## Rampion 2 windfarm proposal EN010117

Janine Creaye IP no 20045132

### Our June assessment of Talbot & Baker II site at Crateman's Farm Cowfold

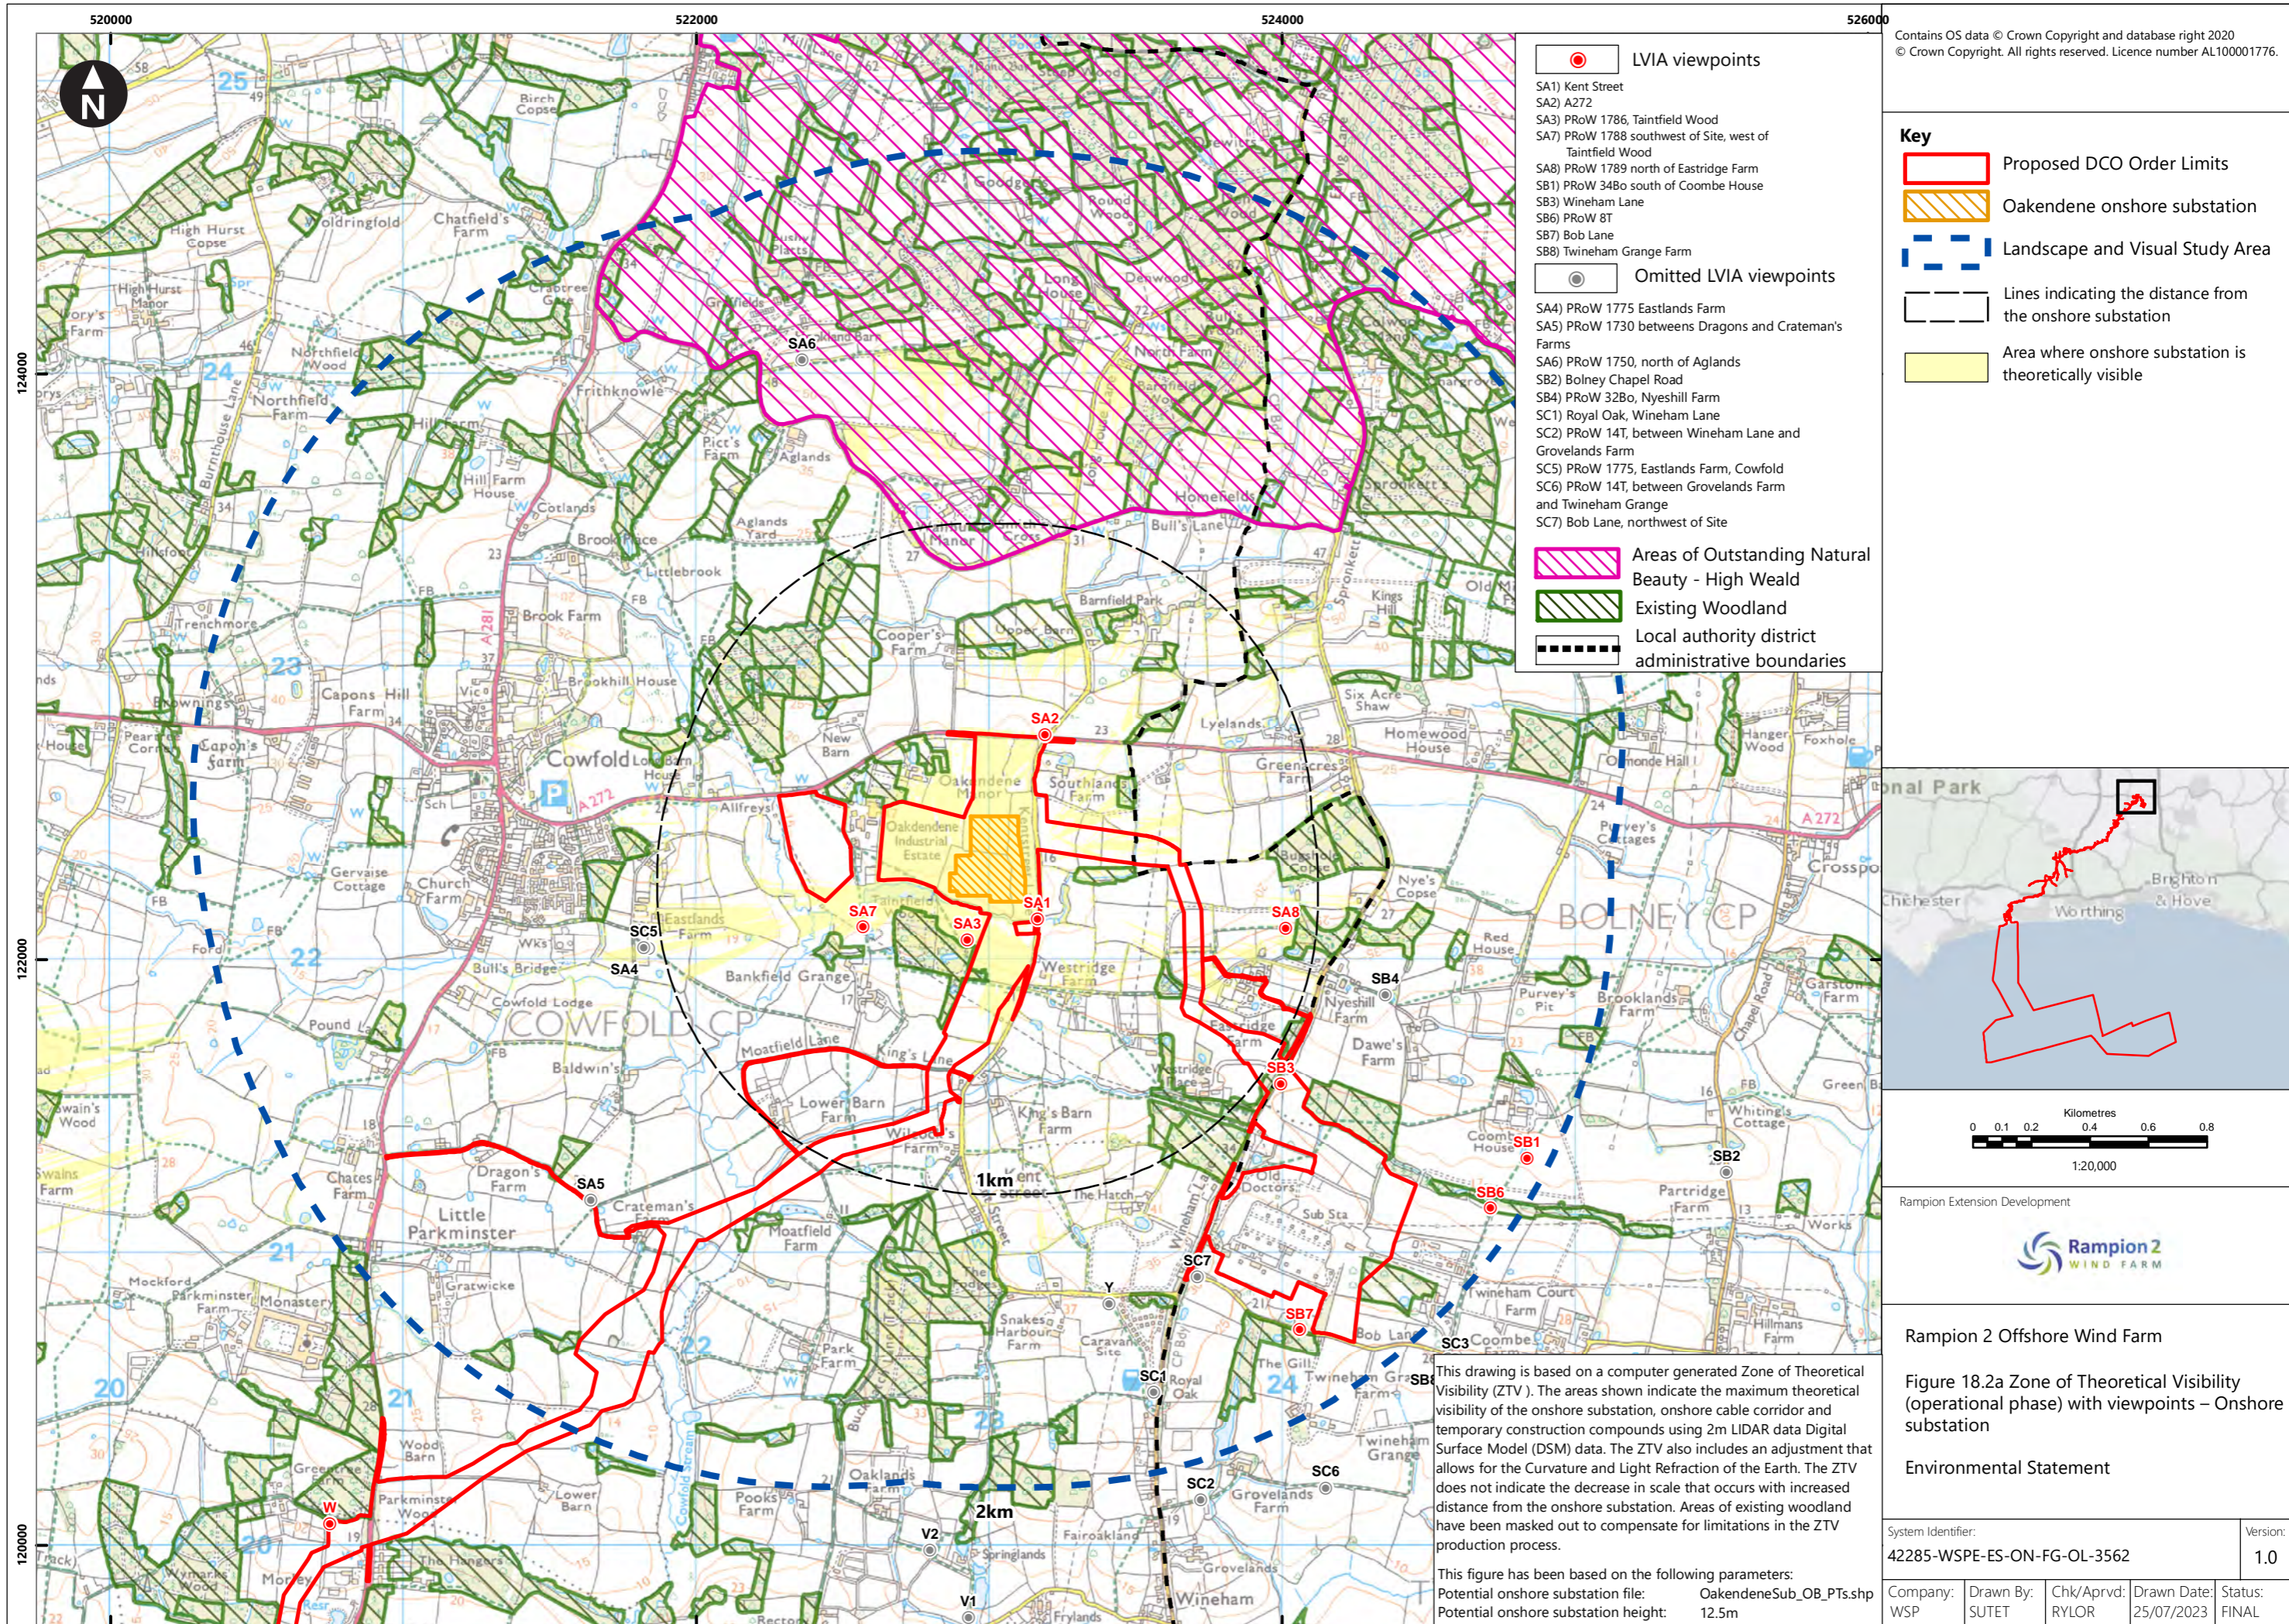
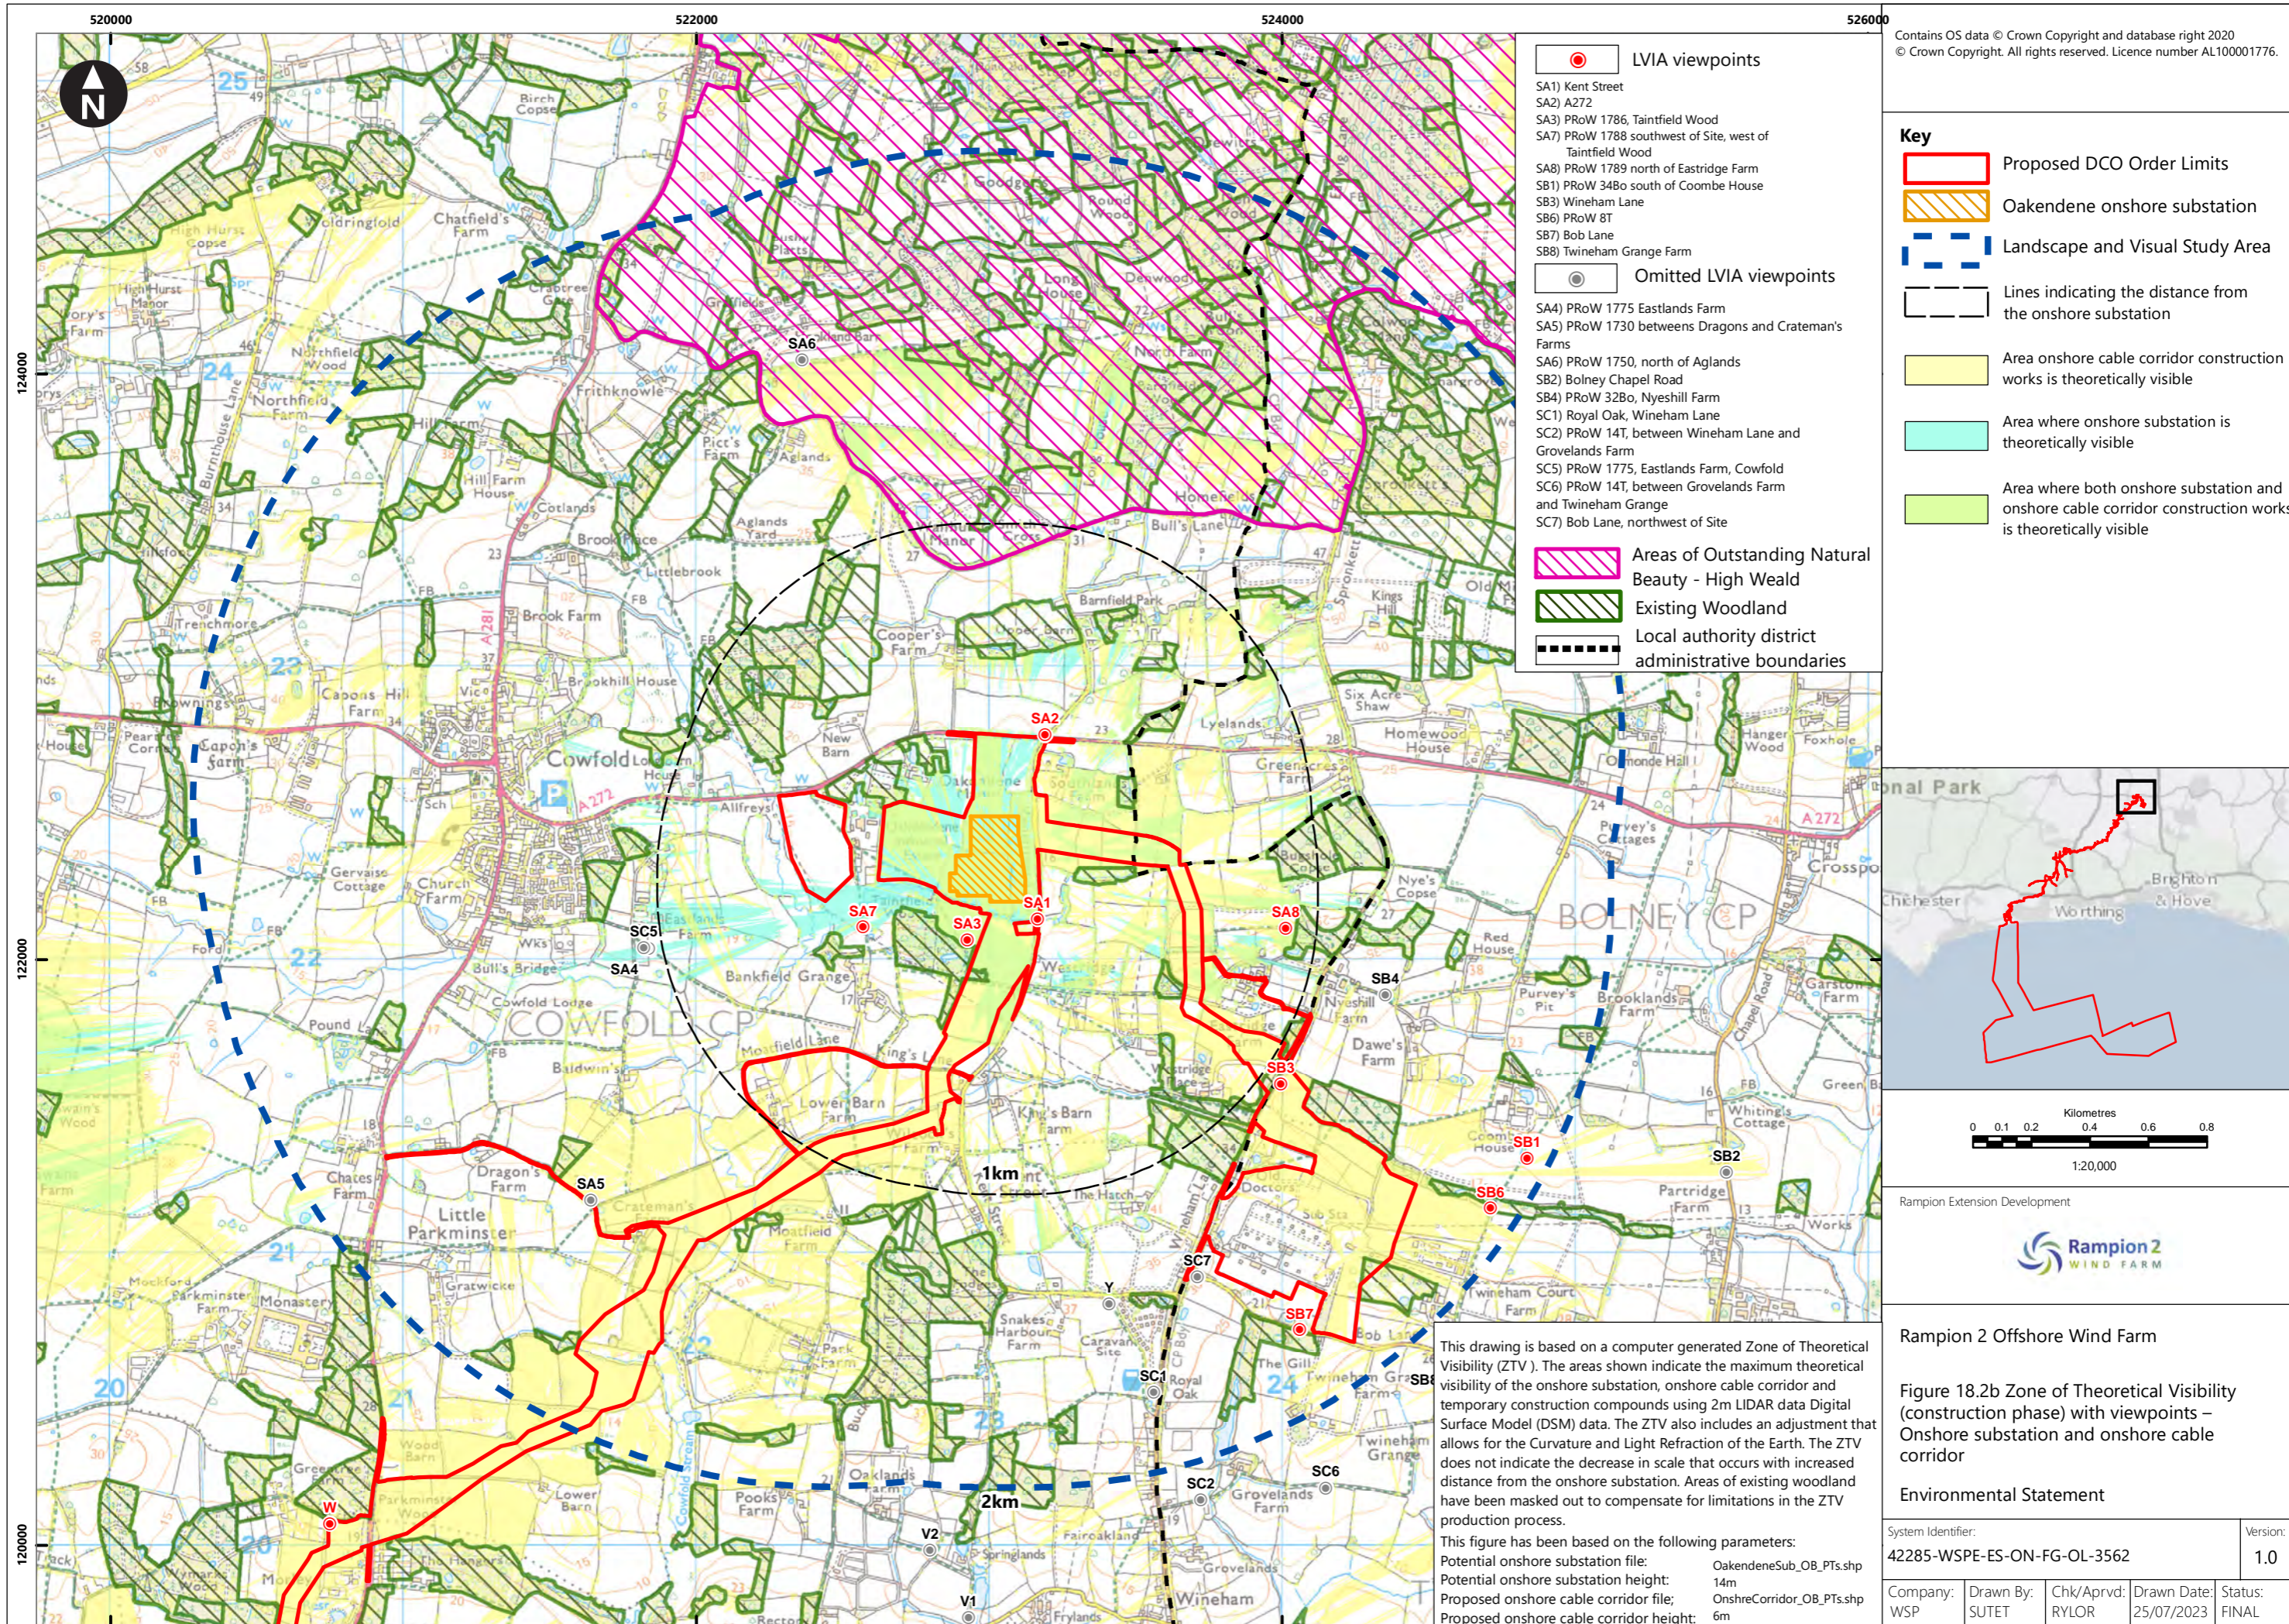
From SA1 REP4-026  
not showing ground shaping, vegetation  
and tree loss or H505 cleared to 20m

- Where are the view point visualisations to show: the actual locations of Access points A61, A64 with the tree loss incurred, the impact of clearing of H505 to 20m, the widening of the junction with A272 with the tree and scrub loss incurred and the concreting over of the verges for the 4 passing places in Kent Street? The deadline 4 images (REP4-026/027) are all irrelevant for Kent Street, out of phase with the process, and very misleading.
